I write further to our pre-commencement site meeting (Condition 17, A/142/16/OUT) and simultaneous review of A/132/19/DOC on 11th October 2019.

We also discussed tree work application A/135/19/T (yet to be determined) in respect of felling tree group G1.
Reason: To implement approved layout under A/168/18/RES.

Rev	-	
Drawing Title		
Tree Protection Plan		
Client	Date	
GD Group	09.10.19	
Project	Drawing Ref	
Merry England	TPP	
Scale	Drawn	Job Number
1:250@A2	JLD	1909

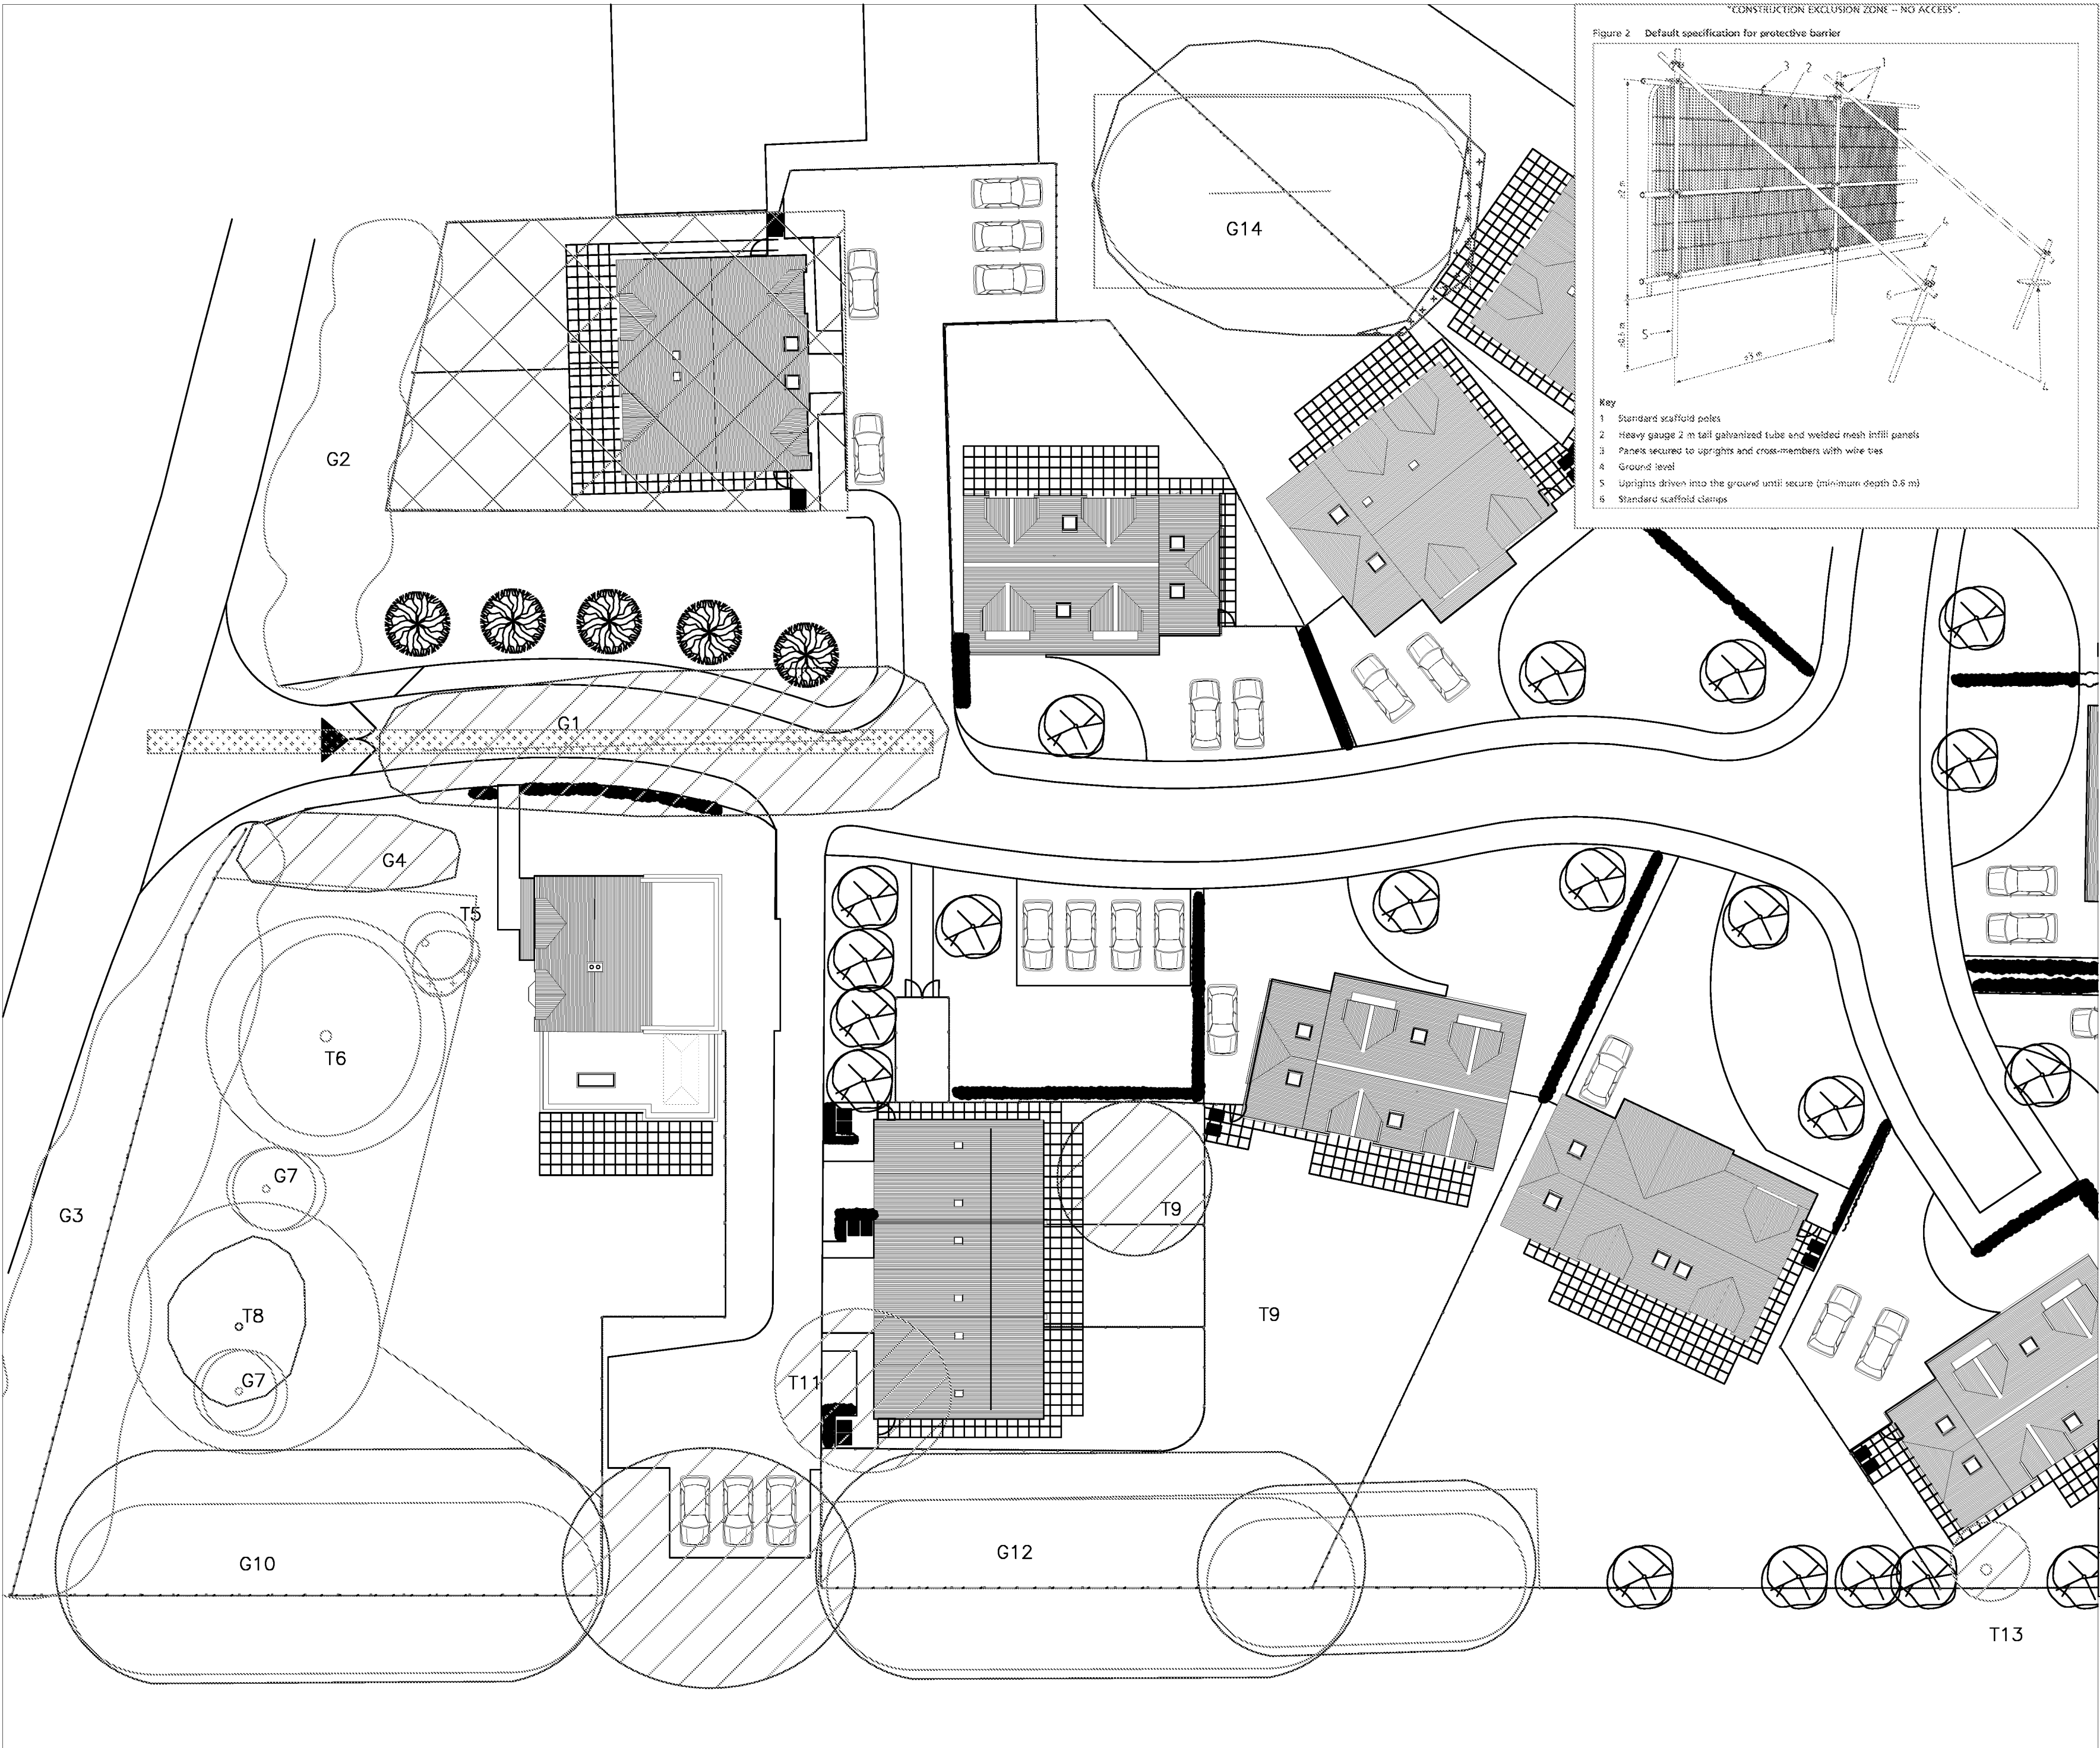
- Joanna/James – please submit details of your replacement tree planting scheme to mitigate the future loss of G1.
- Tree Protection Fencing is largely as shown on the approved plan with only a few minor refinements to be implemented, before that element of the DOC application can be recommended for discharge. Joanna – as discussed, please forward evidence of those refinements in due course (and amended plan).
